Woodshire

Re: Status of Improvement Permit Application #08-5-19958 Lt 166
#08-5-19957 Lt 180

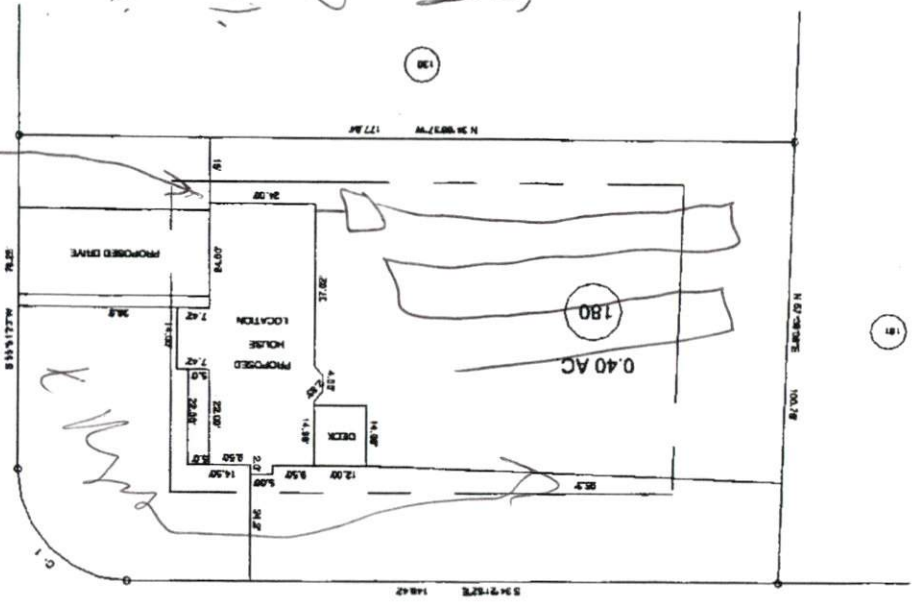
08-500-19957 Lot 180
Woodshire

Change to 3 Bed Rooms And move
house AS shown
